GRANT HAYS ASSOCIATES

DATE: May 17, 2016
TO: Jennifer Bartlett – Maine State Fire Marshal Office
FROM: Mike Hays
RE: Foundation Brewery Expansion
Permit Review Comments
CC: file

Attached are the revisions to the Permit drawings which address your comments dated 4/22/16. All the revisions are Rev-Clouded with a Delta 1 designation. Please let me know if you have any additional questions.

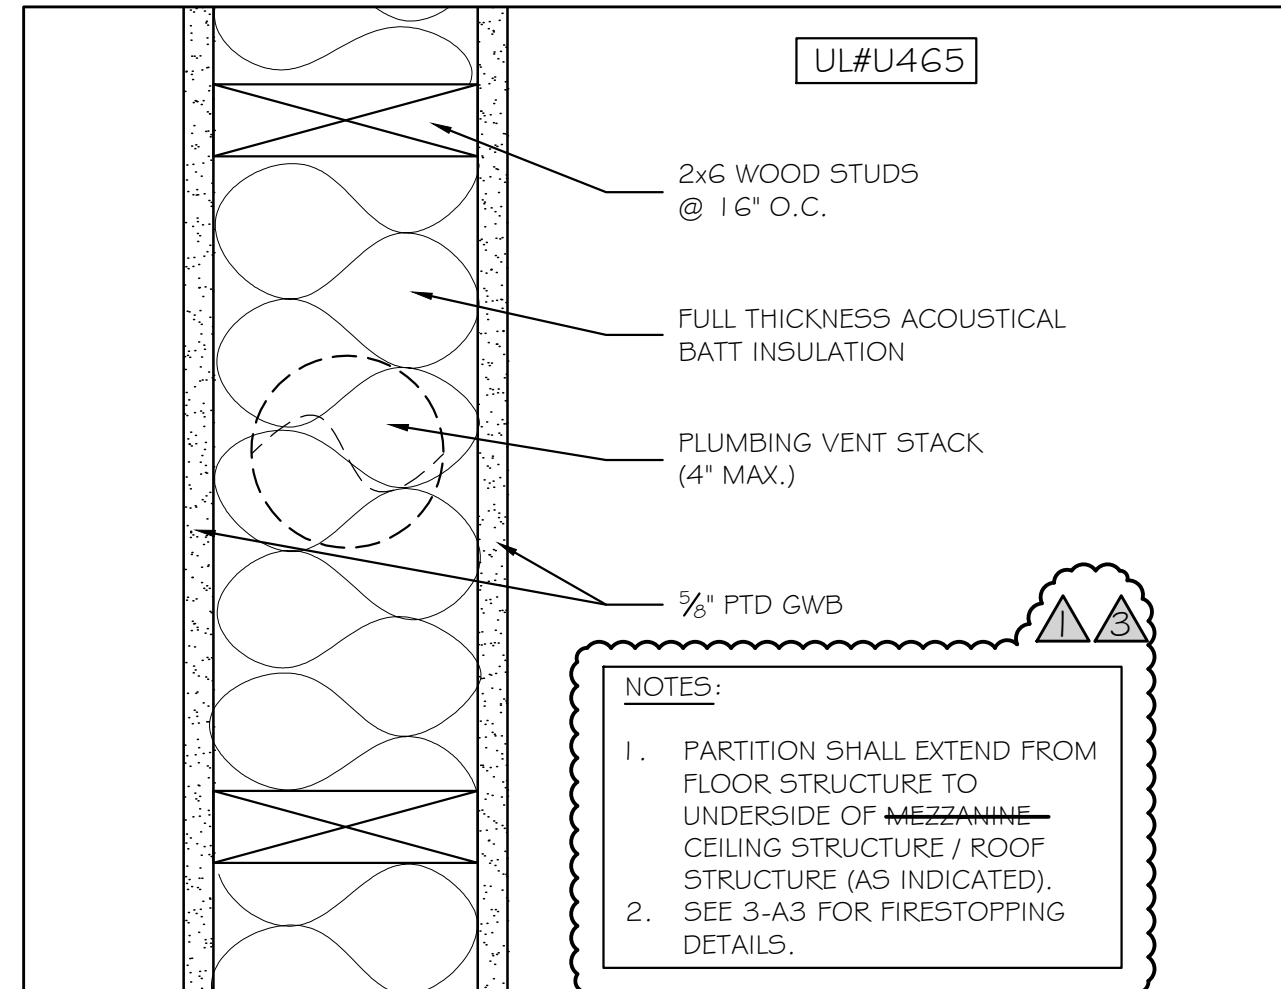
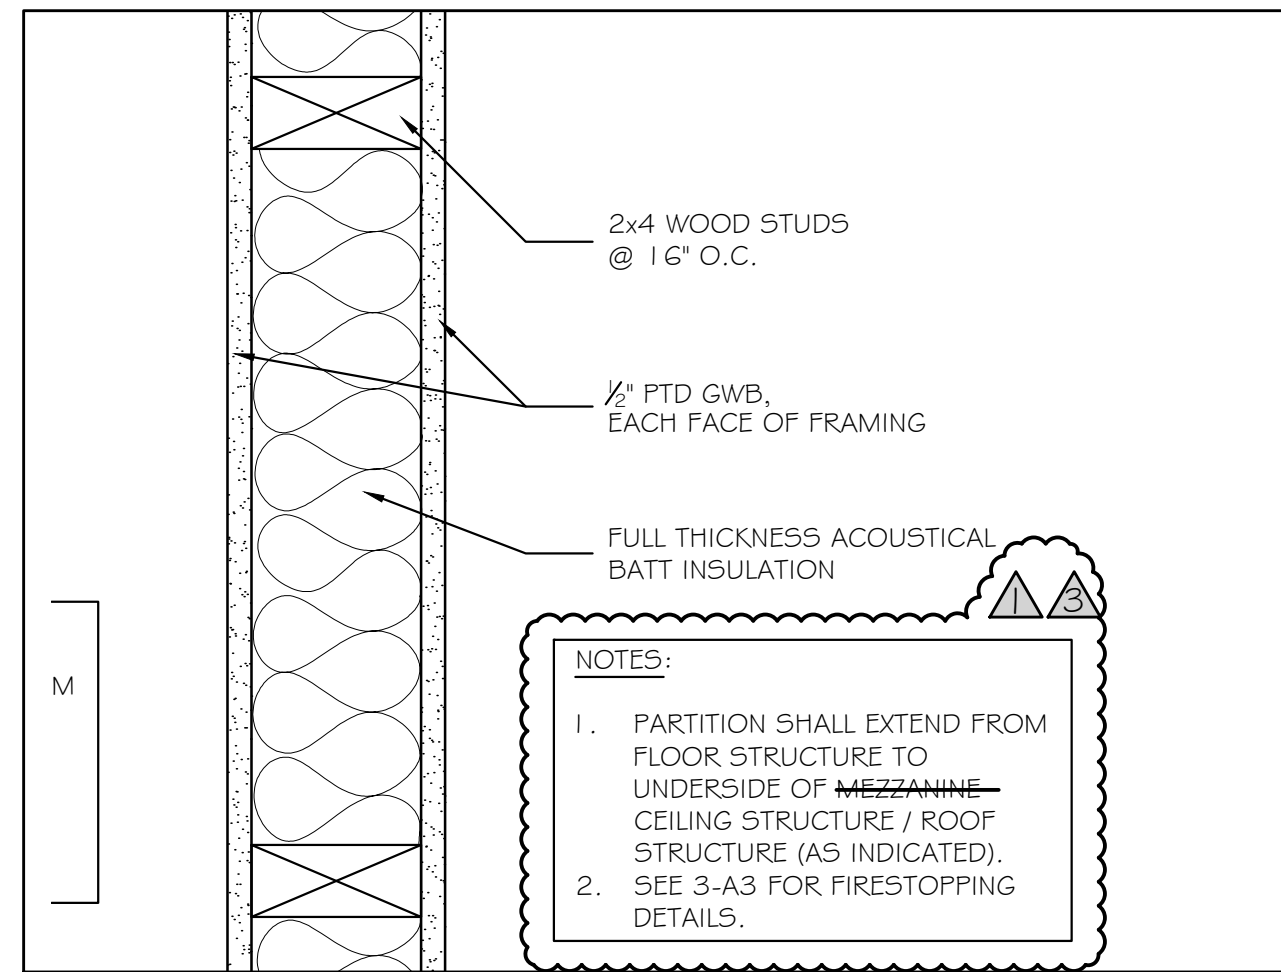
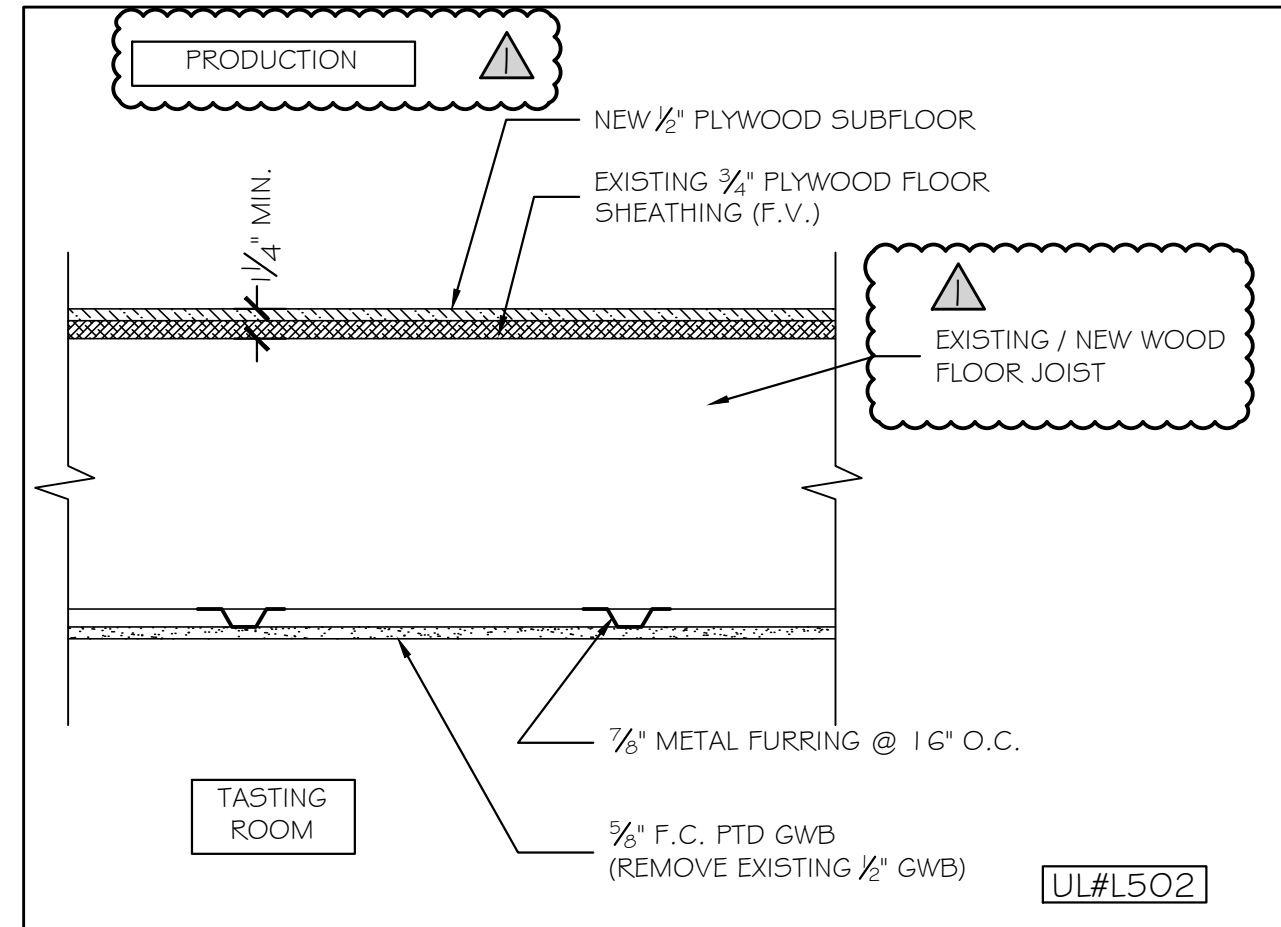
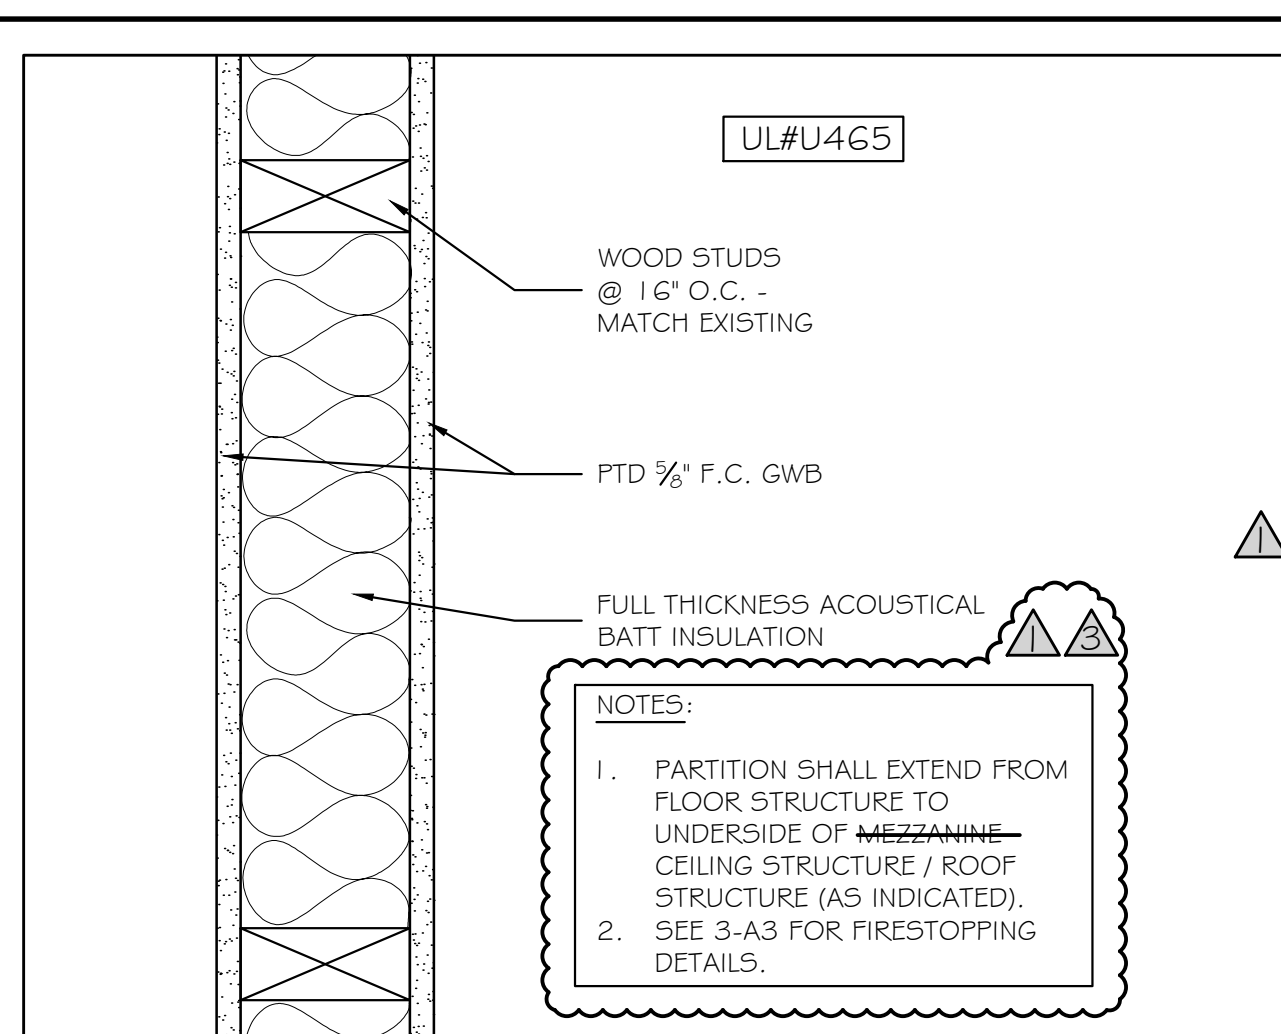
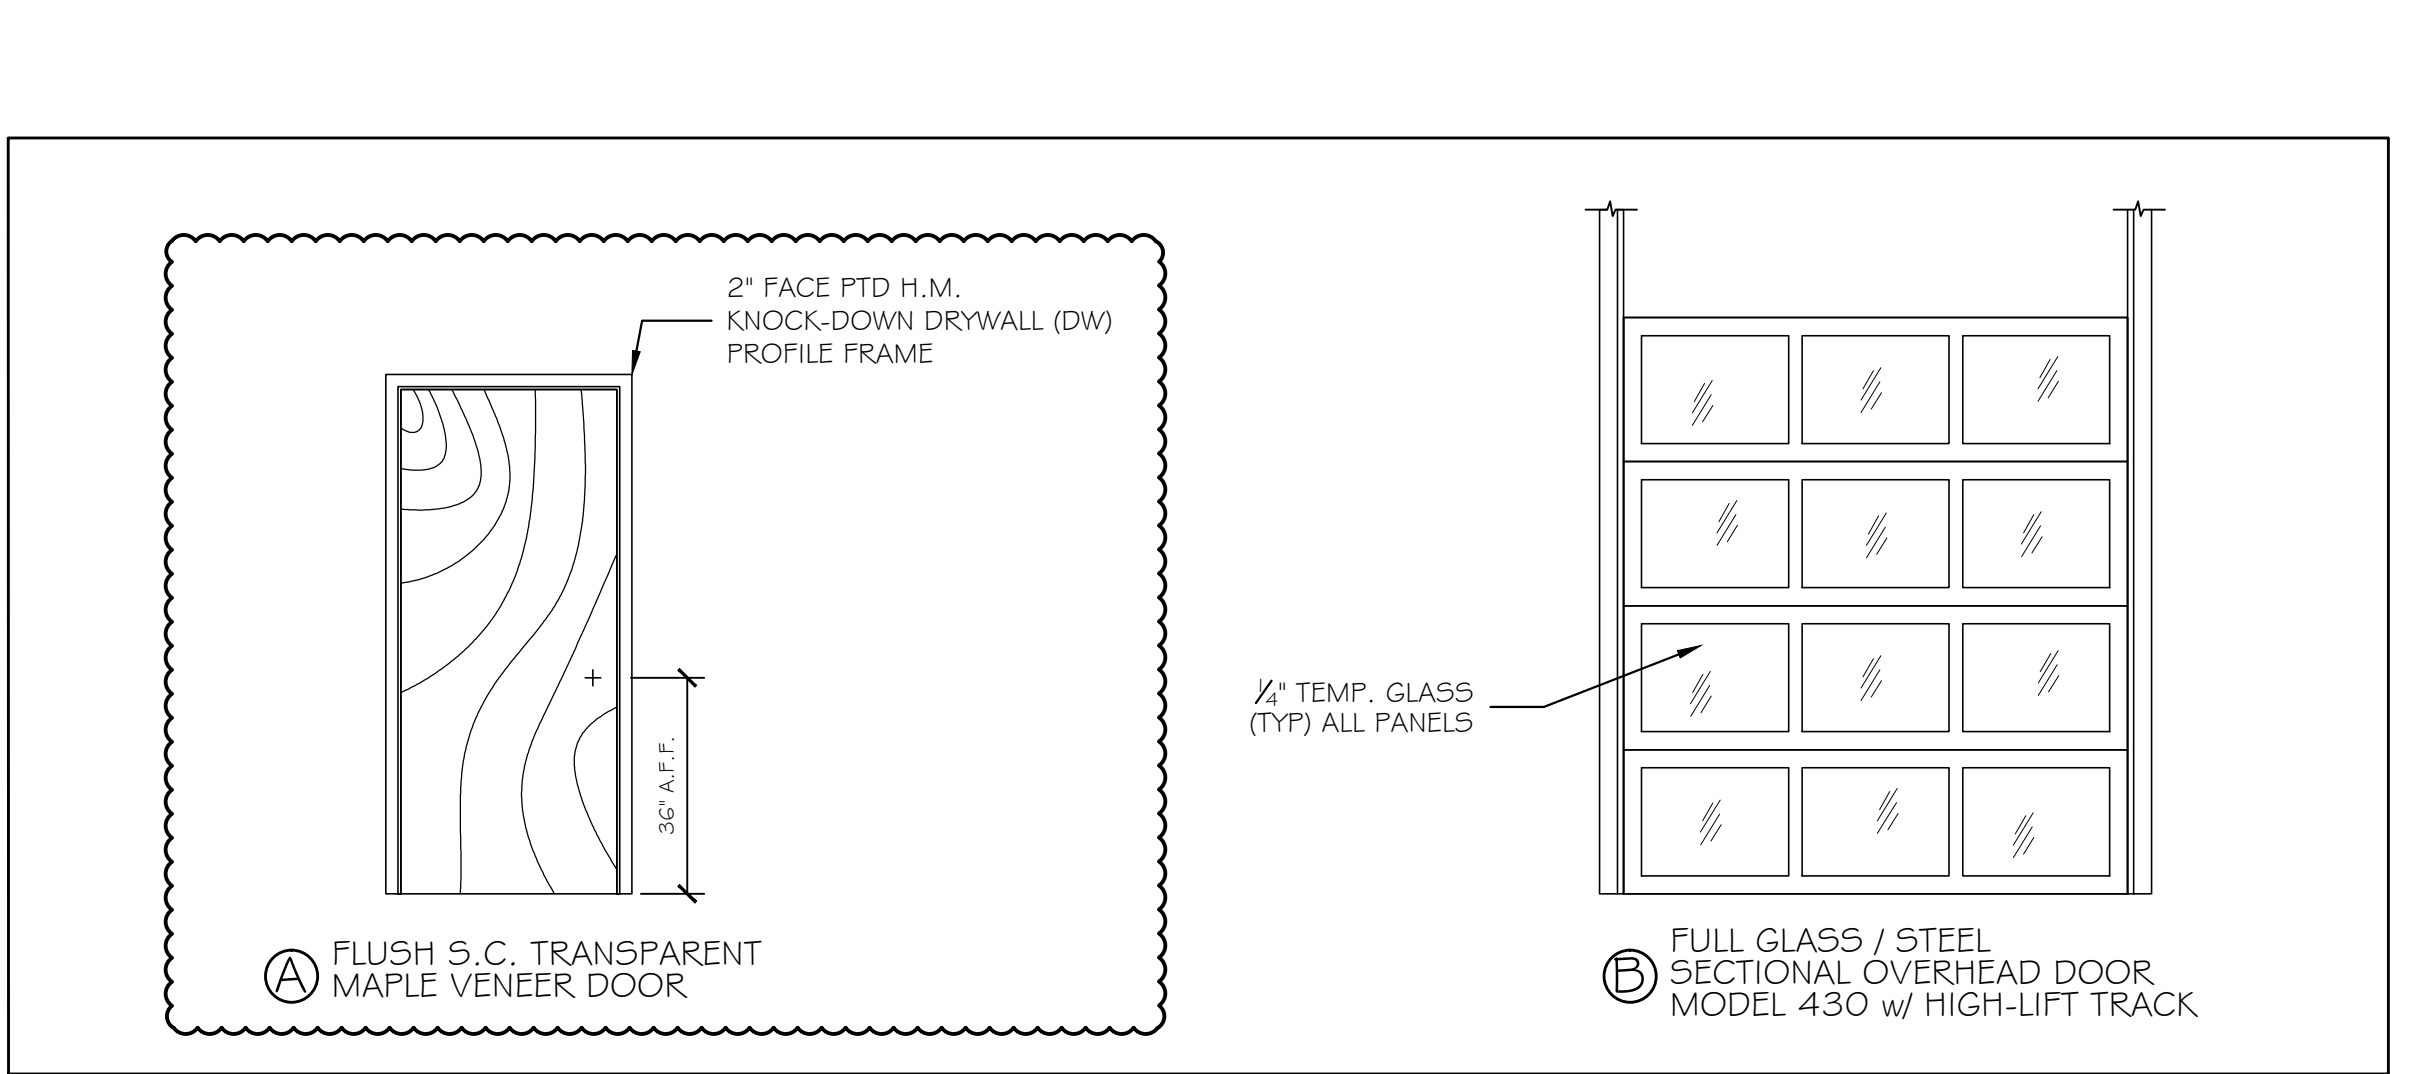
1. Modified Door Schedule to eliminate Fire Shutter and add existing egress doors (E1 thru E3) and door E4.
2. Modified Hardware Sets to identify existing door hardware, and modifications required for #1 above.
3. Modified details 1 thru 4 to reflect comments regarding firestopping.
4. Detail 5 indicates location of existing mezzanine at Production 105 and additional framed floor/guard wall above new ADA bathrooms. This mezzanine is fully separated from Tasting Room 102 from the floor slab to the roof deck above with an existing (1 hour rated) partition. See section at new Sheet A7 for additional clarification.
5. Modified Detail 6 at platform frame atop Walk-In Cooler for existing compressor location. This platform is used for storing empty micro kegs.
